CITY OF ALBUQUERQUE

**Re: Lot 1 Block 2 Unit 18 Volcano Cliffs, S.A.D. 228
6616 Petirrojo NW
Request for Permanent C.O. – Not Accepted
Engineer's Stamp dated: 2-19-18 (D10D003G1)
Certification dated: 10/23/18**

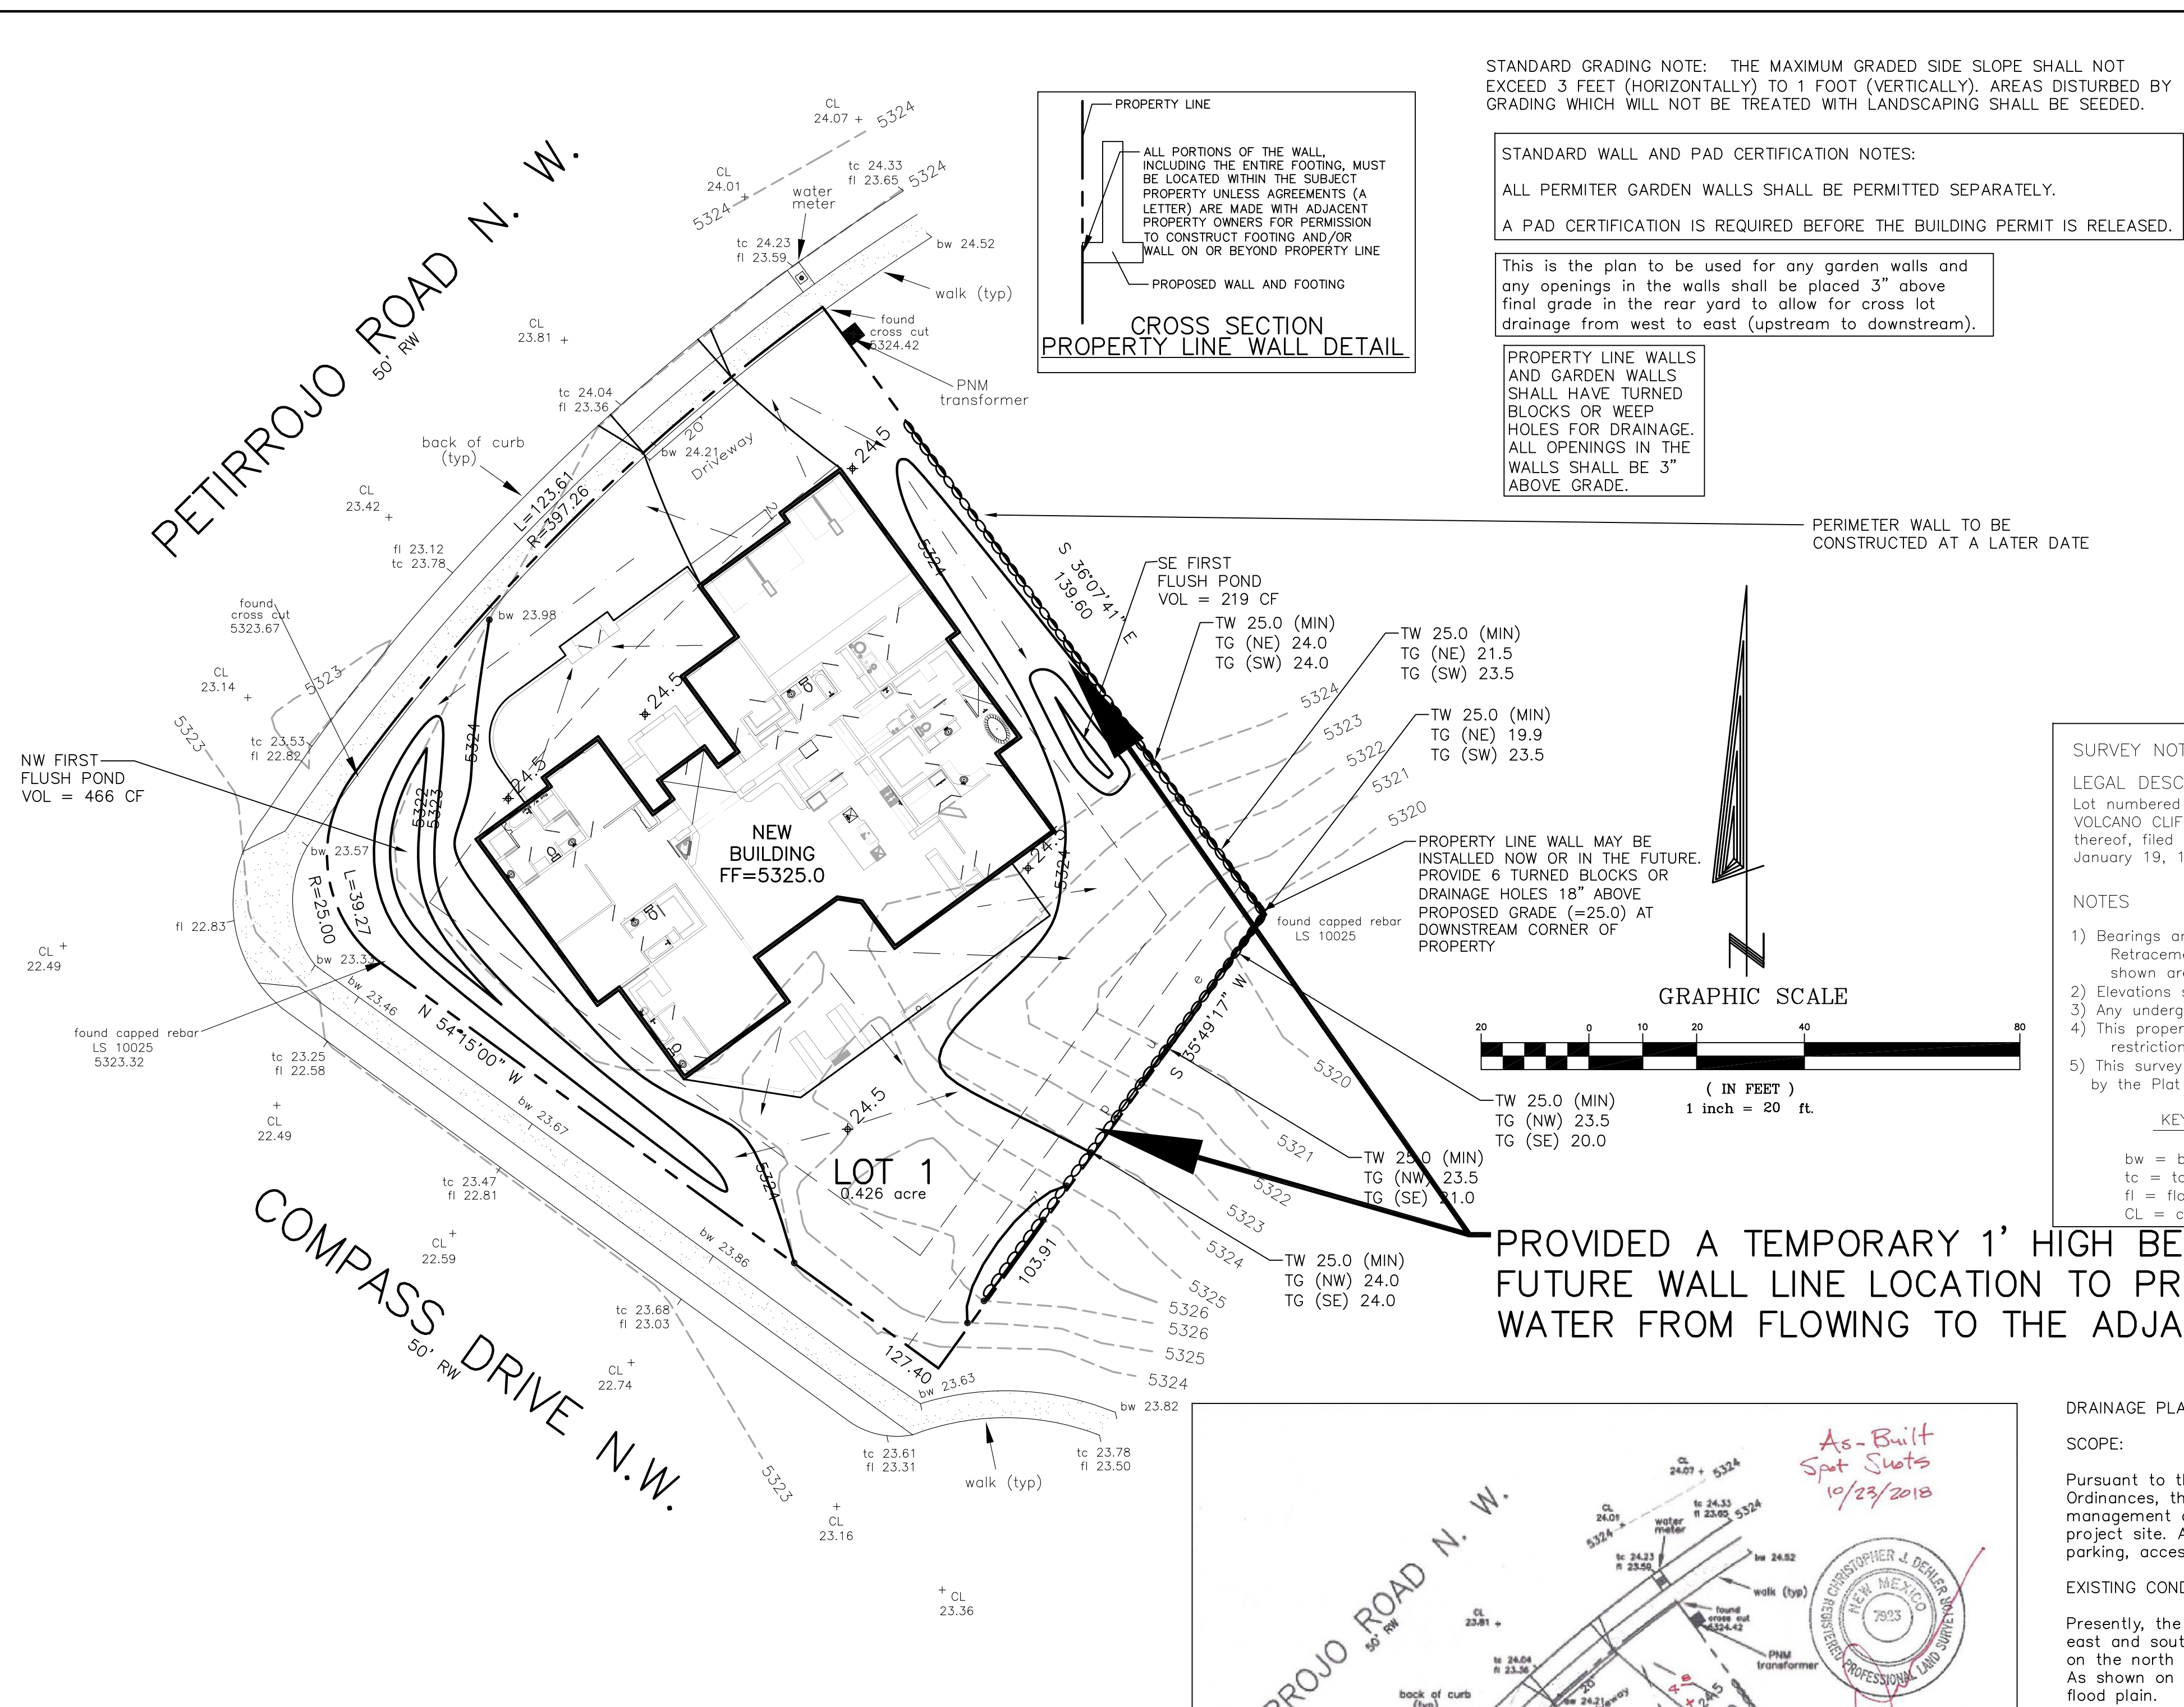
- Remove dirt from used as a ramp in street and sidewalk.
- Provide how the raised lot will be protected from erosion on the North and west sides of the property line.
- Prevent the flows from entering Compass Dr. at the S.E. corner of the lot. All flows must enter the retention pond before flowing out into the public right of way.
- Remove the debris pile and the container from the lot to the north.
